Application for a non-material amendment following a grant of planning permission.

Reference number:	EP/54/21/HH
Date of decision	16/07/2021

Omit side extension to east elevation and relocate garage/store window on southern elevation to new proposed study room. New rendered finish to east elevation to match previously approved application EP/54/21/HH.

Drawing
Proposed ground floor plan

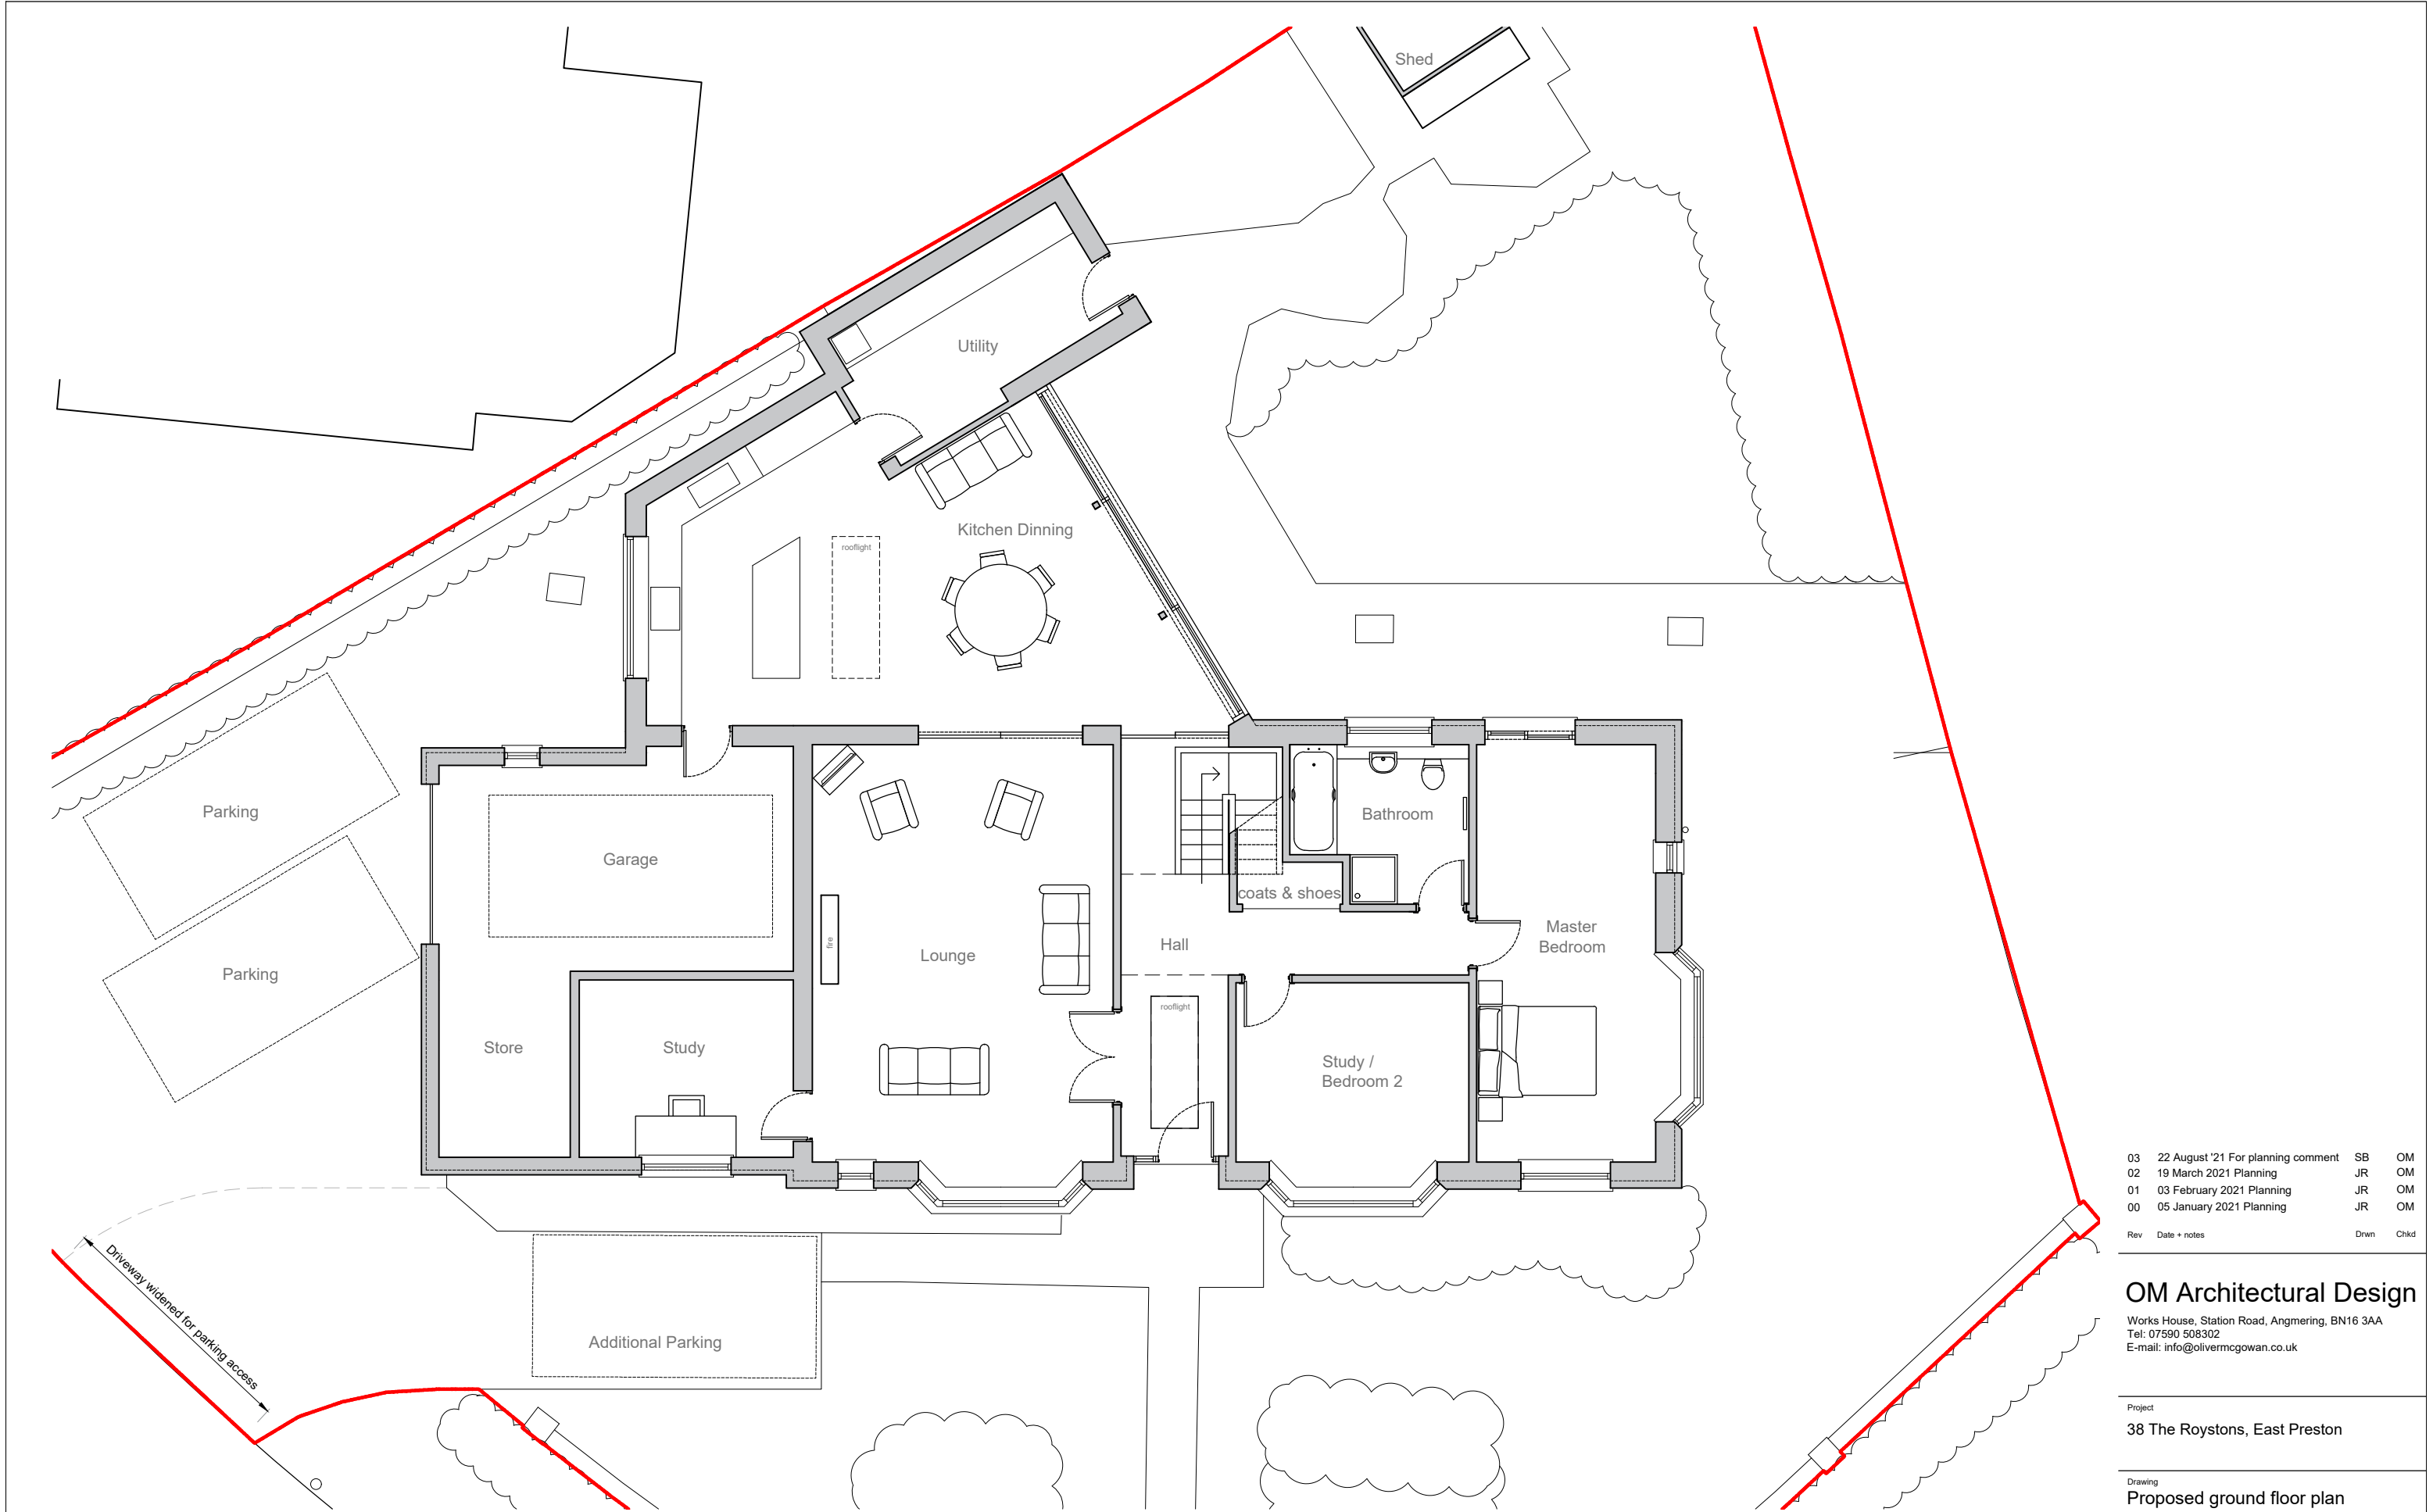
Reduce scope of works to east elevation
New window to study and omit window to garage/store on southern elevation
New rendered finish to east elevation
